Re: The Hacienda, 618 Rio Grande Blvd. NW,

Request for Permanent C.O.—Approved

Engineer's Stamp dated: 6-22-09 (J-13/D063)

A PROPOSED DRAINAGE PLAN
FOR
"THE HACIENDA"
618 RIO GRANDE BLVD. N.W.
ALBUQUERQUE, NEW MEXICO
JUNE, 2009

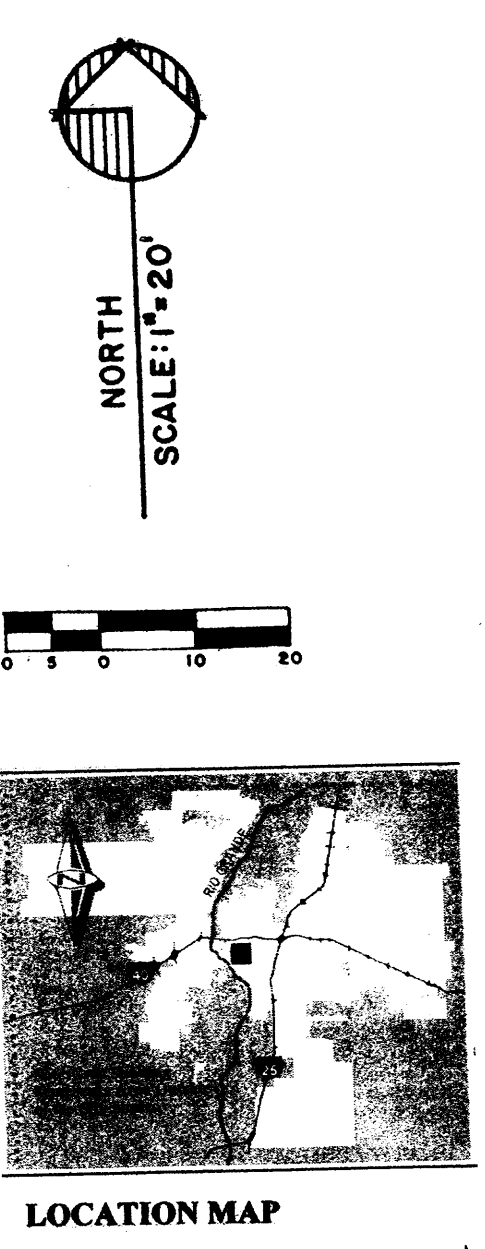
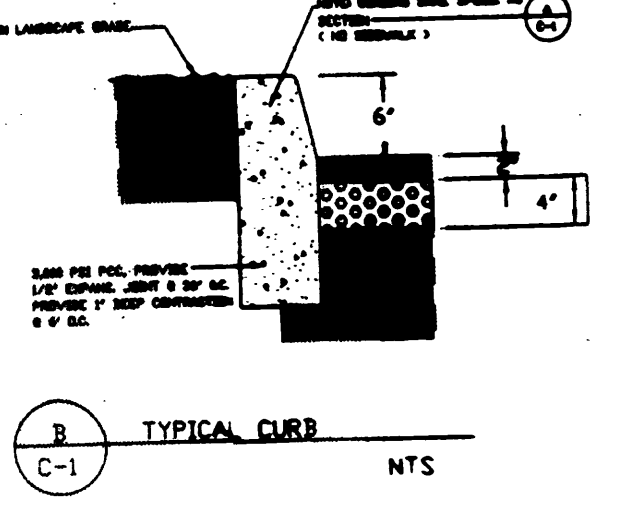
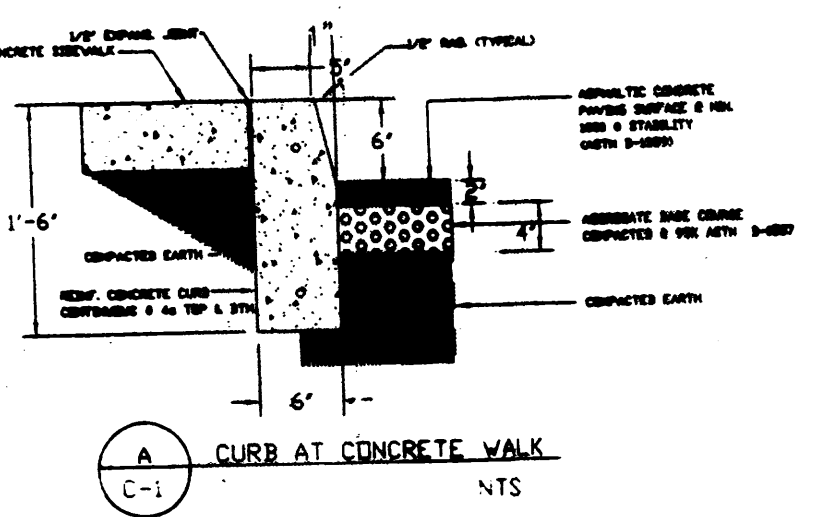
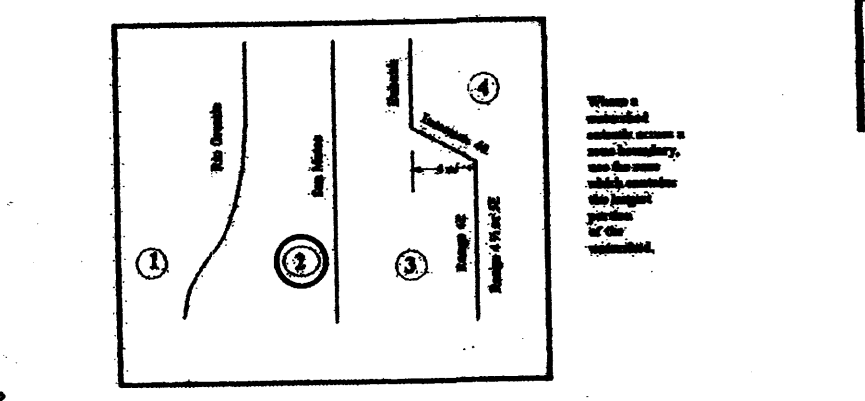
All sidewalk culverts will need to be inspected and approved by Duane

Schmitz prior to issuance of any certificate of occupancy, temporary or

Based upon the information provided in your submittal received 6-24-09, the above referenced plan is approved for Building Permit and SO 19 Permit with the understanding that the Keyed Note "A" area will become a depressed water harvesting area. As-built this area on the Engineer Certification.
